## Inspector's Report ABP-317659-23

Whether the (a) demolition of a two-storey extension measuring 92 sq. m. to the rear of dwelling, (b) construction of new two-storey extension measuring 129 sq. m. to the rear of dwelling, (c) demolition of a single storey sunroom measuring 5 sq. m. on the western side elevation, (d) construction of a single storey extension measuring 2 sq. m. on the western side elevation, (e) construction of lean-to roof on the western elevation measuring approx. 6900mm long and 160mm wide and (f) construction of a wooden fence measuring 2m in height along the western boundary in the front garden of the house is or is not development or is or is not exempted development.

10 Burrow Road, Sutton, Dublin 13

Scale 1:100 @ A1

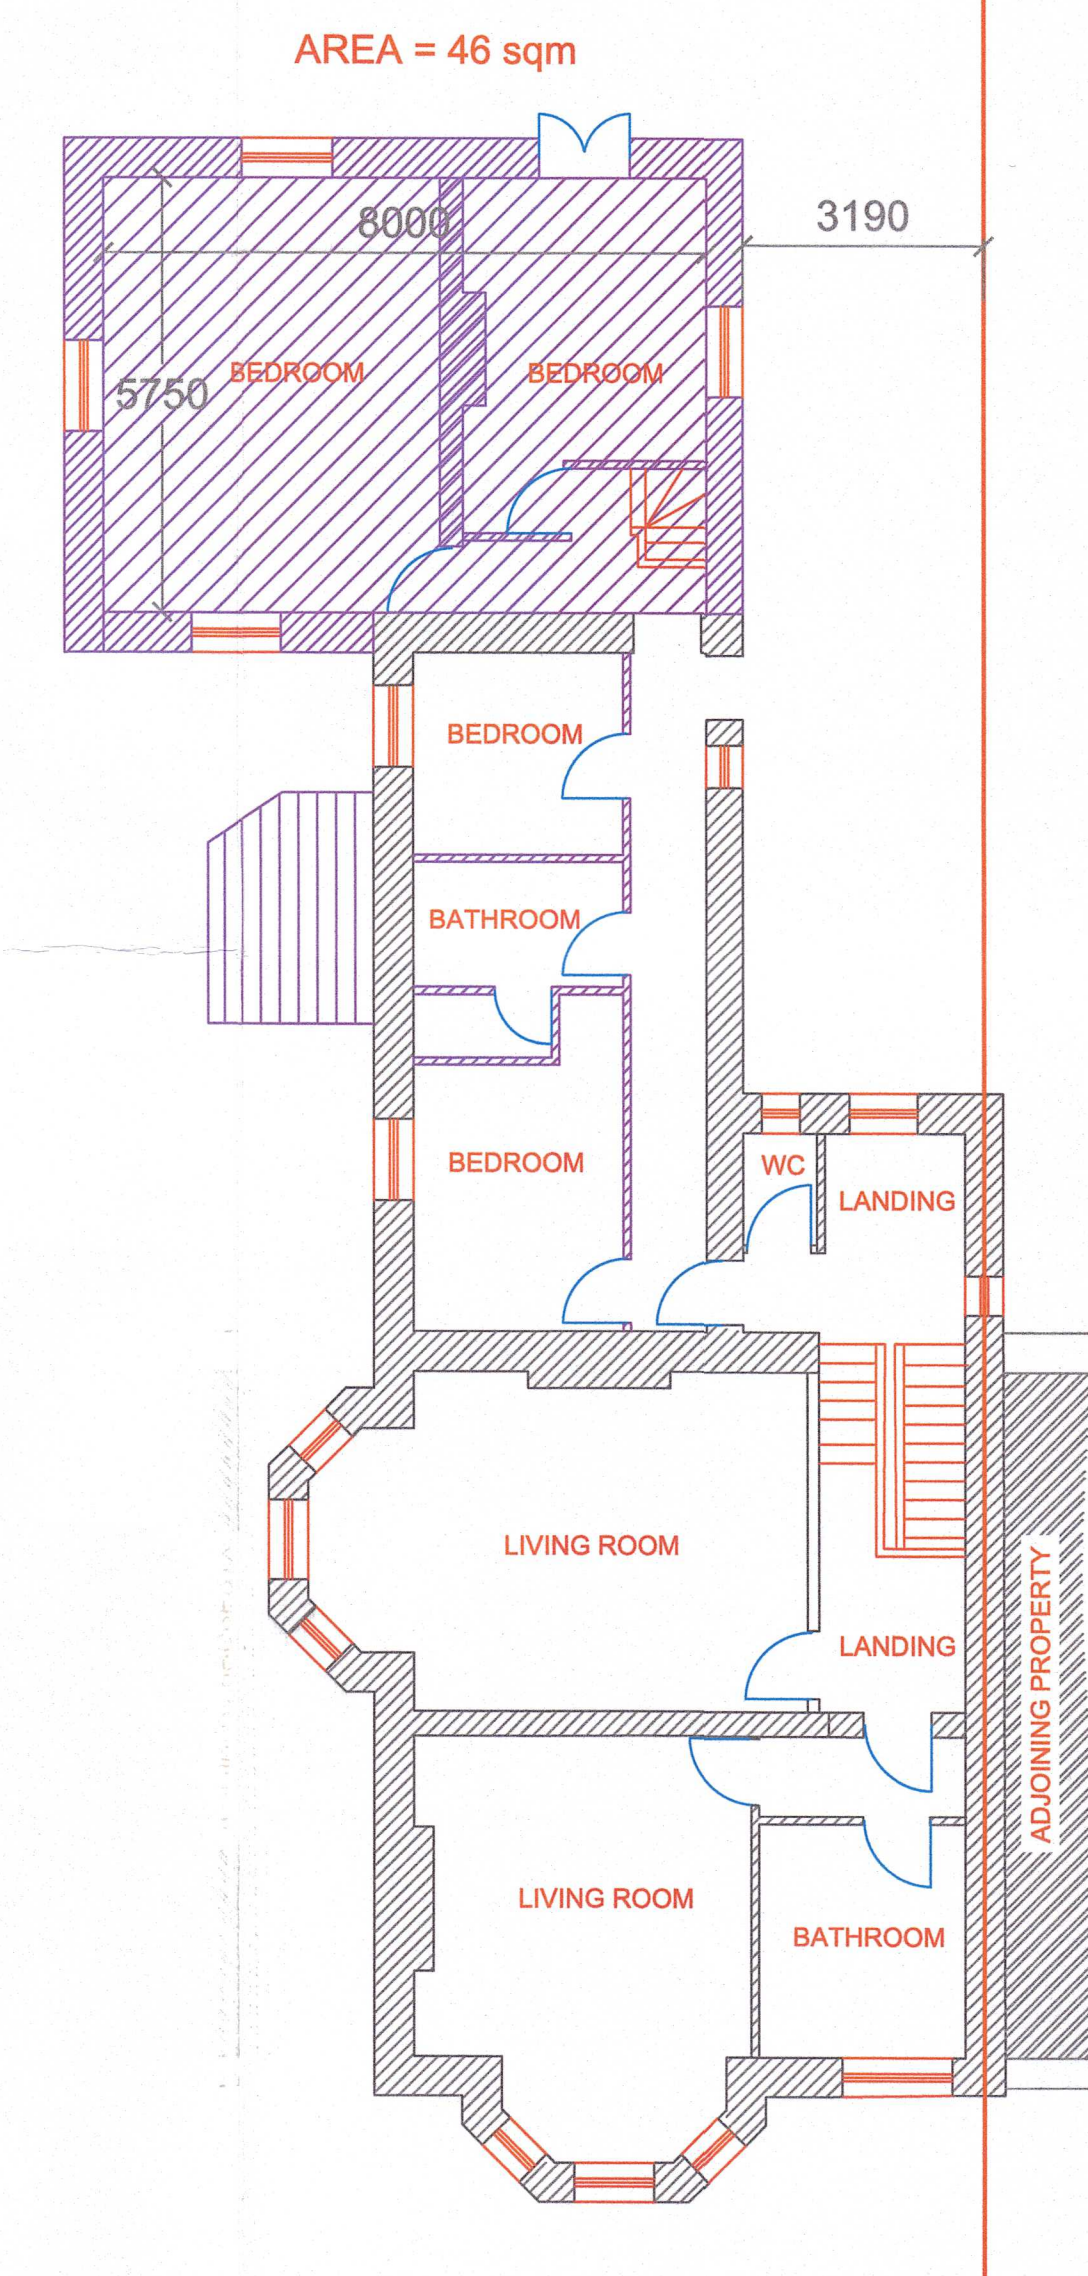
- 8.1.6. Both the pre-existing and existing extensions are shown on plans and elevations submitted by the referrer (FCC). The plans of FCC detail a two-storey extension with a total GFA of 129sqm (73sq.m at ground floor level and 56sq.m first floor level). Mr Farrelly disputes the dimensions as shown on FCC's drawings stating that the new extension extends to 123sqm GFA, (71sqm at ground floor level and 52sq.m at first floor level). Additional plans and elevations were included as part of Mr. Farrelly's Referral Response statement; however, there drawings are not shown to scale. The Board will note that the dimensions (internal room length and width) shown on both

sets of drawings are the same. For example, the dimensions of the first-floor master bedroom are shown on both sets of drawings as 7.7m(l) x 6.760m(w) which equates to a floor area c52sqm. However, this calculation does not include the additional floor area contained within the small link corridor newly constructed between the main dwelling and the master bedroom, which is shown on the drawings to incorporate a WC. The corresponding space at ground floor level is occupied by a 'lobby'. This leads me to believe that the discrepancy in floor area calculations arises from the inclusion or not of the floor area within this 'link' space. However, this view is based solely on my review of the plans submitted, I did not take any internal measurements of the extension and therefore I cannot verify the floor areas. Notwithstanding, I am satisfied that this issue does not need to be resolved for the purposes of this assessment and I am satisfied that the Board can make a determination on the referral questions based on the information available.

- 8.4.7. As detailed on the drawings submitted, the pre-existing two storey extension was positioned behind the rear (northern) building line of the original house (as it appears on the Historic 25-inch map) and projected approximately 4.1m from the dwelling’s western elevation. Therefore, prior to demolition it could be argued that the rear of the house was defined by the northern elevation of the pre-existing extension. However, as previously established, once the pre-existing extension was demolished, it ceased to exist and therefore in my opinion, the rear of house at the time of the construction of the new extension was defined by the northern elevation of the original house (as it appears on the Historic 25-inch map).

8.4.8. As detailed on the drawings submitted, the new two-story extension (the subject of this referral) is partially constructed over the footprint of the pre-existing extension. It is positioned behind the rear (northern) building line of the original house and projects c3.7m to the side, beyond the dwelling's primary western elevation. Since the new extension projects significantly to the side, beyond the side elevation of the original dwelling, the extension cannot, in my opinion, be classified as being 'to the rear of the house'. I therefore consider that the exemption under Class 1 cannot apply in this instance. In support of this position, I refer the Board to referrals RL.2107, RL2506 and RL3115, where the Board determined in all cases, that an extension to the rear of an existing house that projected significantly to the side, beyond the side elevation / gable was not exempted development.

- **Cond's 1 and 2** relate to floor area, both conditions place a restriction on the size of any qualifying extension at 40sqm. The distinction between these two conditions is whether or not the house has been extended previously. In this case, although the house has been extended previously, said extension has been demolished and no longer exists. As such I consider that Cond 1(a) "where a house has not been extended previously" to be the relevant limitation. In support of this position, I refer again to referral RL.2455. The newly constructed extension with a floor area of c123sqm, far exceeds the 40sqm limit set by Cond. 1(a). The floor area of the extension above ground level (+52sqm) also far exceeds the 12sqm limit set by Cond.1(b).

- **Cond. 3** requires a separation distance of not less than 2 metres between any above ground floor extension and any party boundary. I am satisfied that this condition has been complied with.
